Engineers Comments Regarding Surface Water Drainage

APPLICATION NO: AL/27/20/PL

Site Address: Springfield Hook Lane Aldingbourne PO20 3TE

Description of Works: Demolition of the existing dwelling & construction of 2 No. 2-bed, 3 No. 3-bed & 4 No. 4 bed houses including access, landscaping & associated works (resubmission following AL/51/19/PL).

Proposed Block Plan 1:500@A3

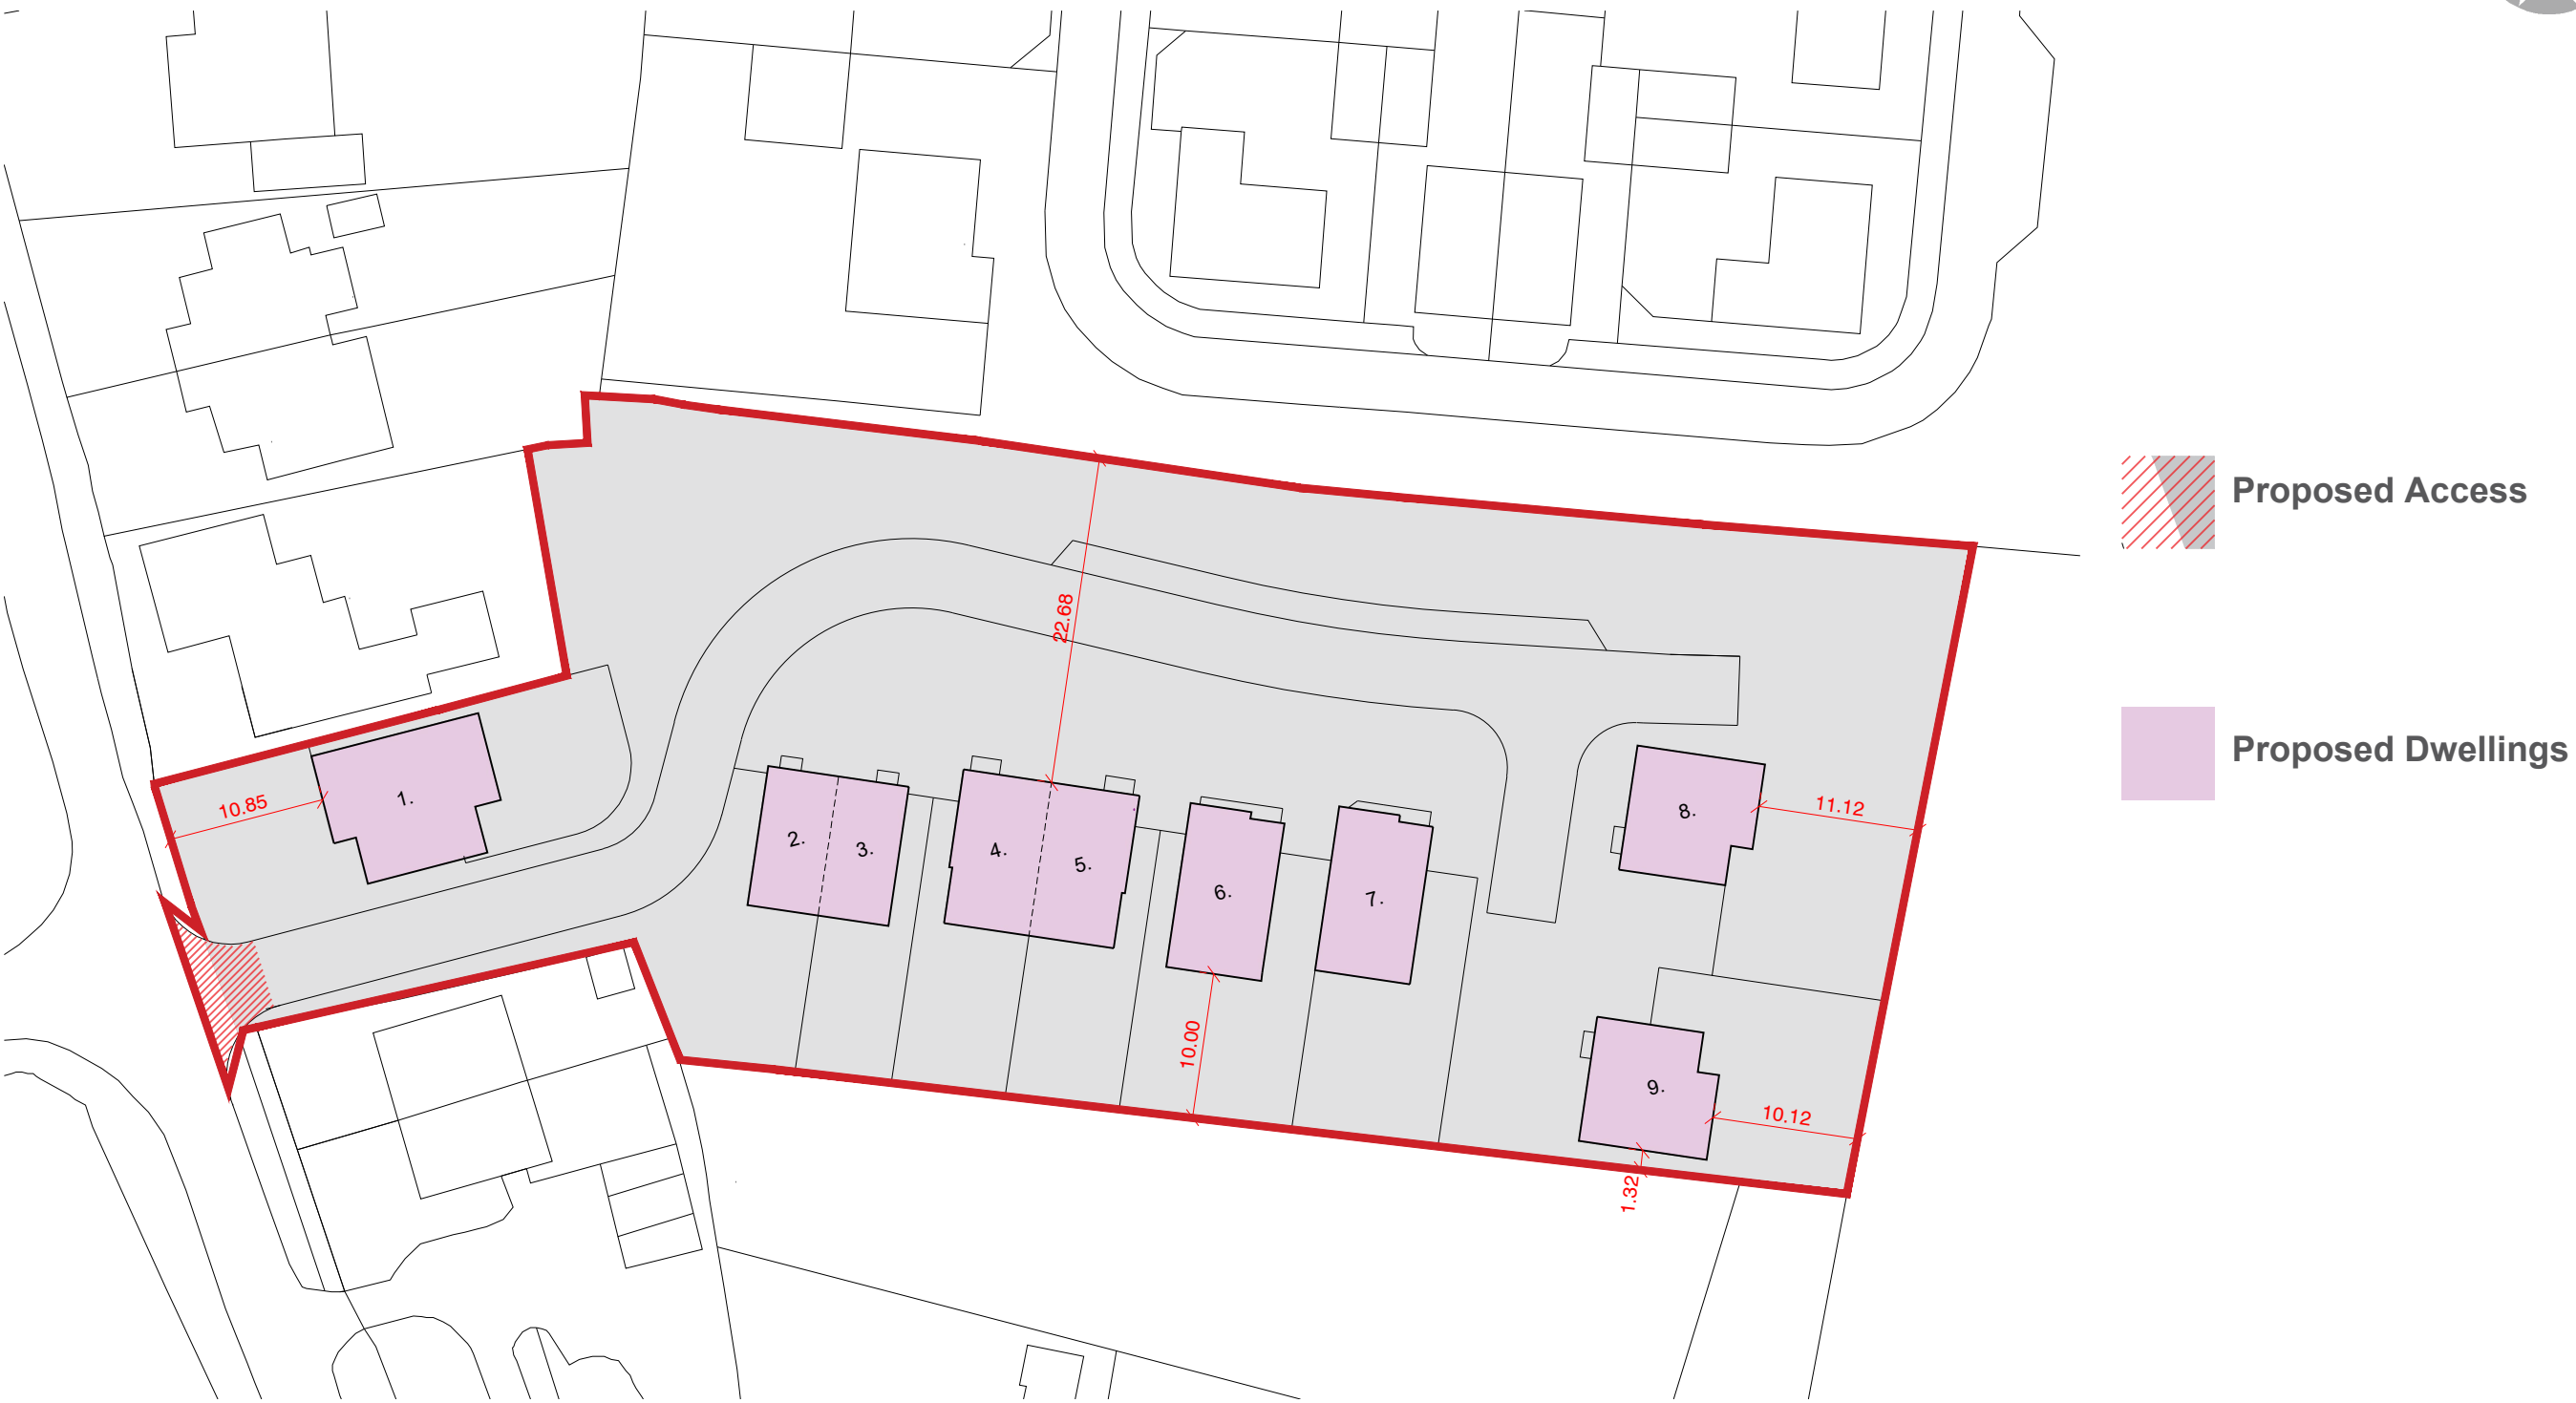
6. Depending on the results of the groundwater monitoring it may be necessary to provide a counter to buoyancy in any attenuation solution.
7. The applicant is reminded that all houses, fences and walls must be kept at least 3m from the top of the bank of the watercourse on the northern boundary of the site.
